From: Ben Favier [REDACTED]
Sent: 17 March 2022 17:04
To: Planning.Responses [REDACTED]
Subject: Re: Request for further information FP/42/22/CLP

DRAWING
As Proposed
Site Plan

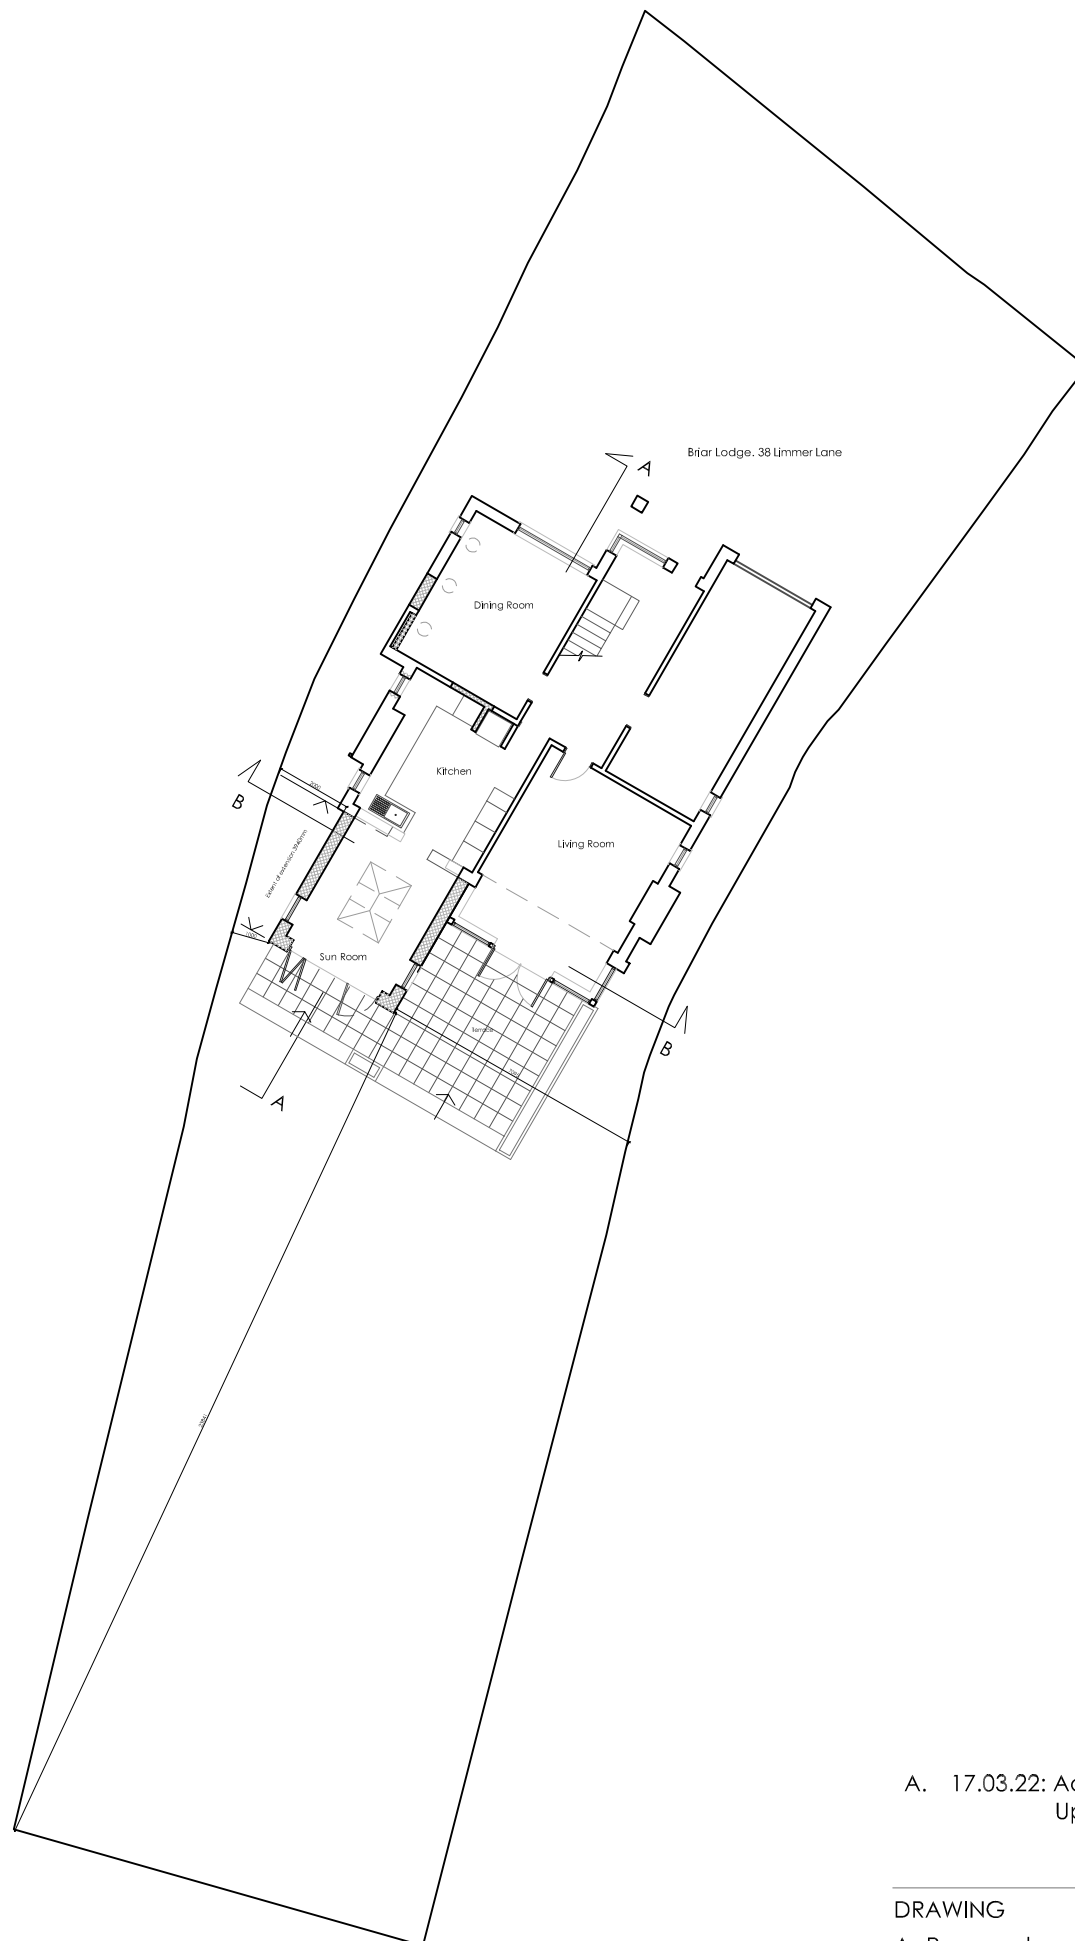
- dimensions added to the site/block plan (distances from the boundaries).
- Windows to NW and SE elevations of extension have been amended to match the ground floor plan.
- the new window in existing archway has been amended on floor plan to match the NW elevation.
